From: Stephen Kilmartin
Sent: 20 November 2025 12:29
To: [REDACTED]
Subject: FW: 3/2025/0667 and 3/2025/0668 - Alder House Holden Lane Bolton by Bowland BB7 4LZ

Sorry to come back to you, I would need the same information on parking provisions for application 3/2025/0668, too. The location plans for both the proposals (25/0668 and 25/0667) also do not include the access track within the red edge, which needs to be included up to the adopted highway line. Given that these proposals will result in an increase in dwellings along the private access track, please can a detailed site access plan for the junction with Holden Lane be provided along with a detailed access track drawing, showing any existing passing places along its length.

From: Walsh, Kathryn
Sent: 27 October 2025 14:59
To: Stephen Kilmartin <[REDACTED]>
Subject: 3/2025/0667 - Alder House Holden Lane Bolton by Bowland BB7 4LZ

DRAWING
Expanded Proposed Site Plan

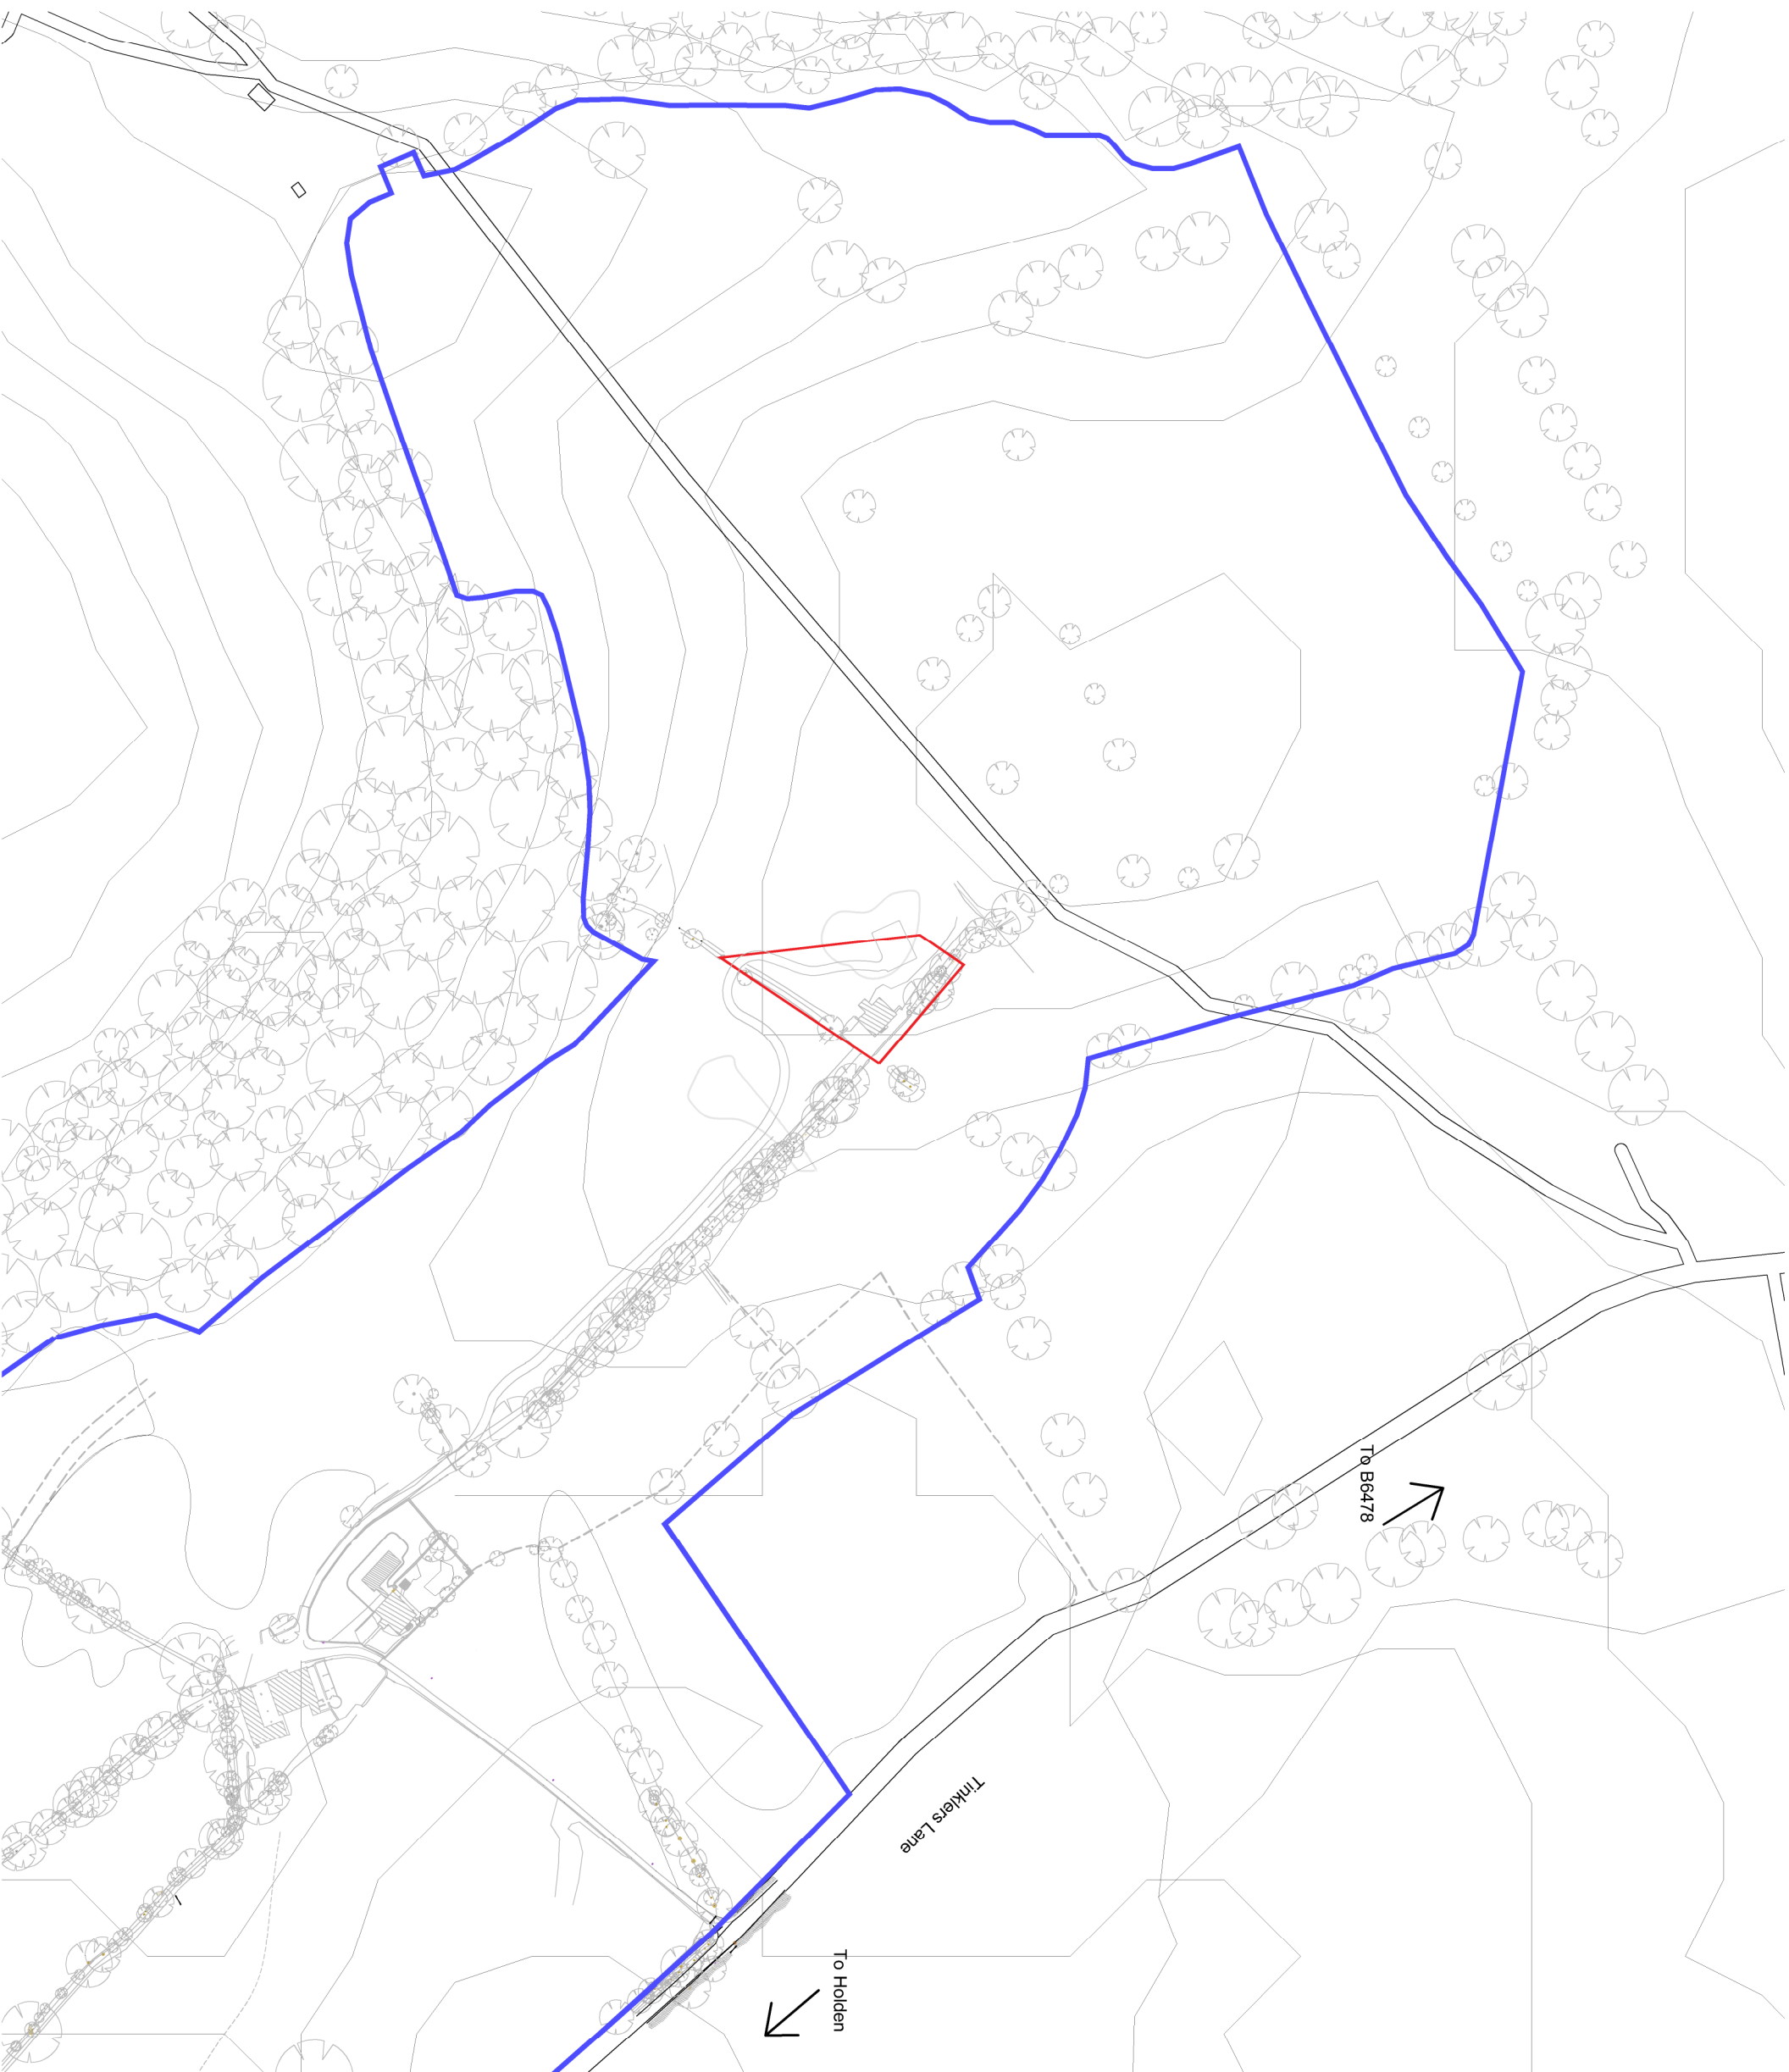
A detailed parking plan showing at least 3 parking spaces, measured 2.4m wide and 5m long. Where they are adjacent to a fence or similar obstruction an additional width of 0.6m should be provided and if the driveway/parking area has shared pedestrian access an additional 0.8m should be provided.

Clear turning provisions, given the need to enter and exit in a forward gear to ensure there is no reversing on Holden Lane and remove any conflict on the private access track.

An amended location plan including the access track up to where it meets the adopted highway.

A detailed drawing of the access track, showing the width and any existing passing places along its length to ensure minimal conflict on the private track and prevent any reversing back to the access point with Holden lane.

A detailed site access drawing – to ensure it is an appropriate width and length to support access to 3 dwellings and remove any conflict occurring on Holden Lane.
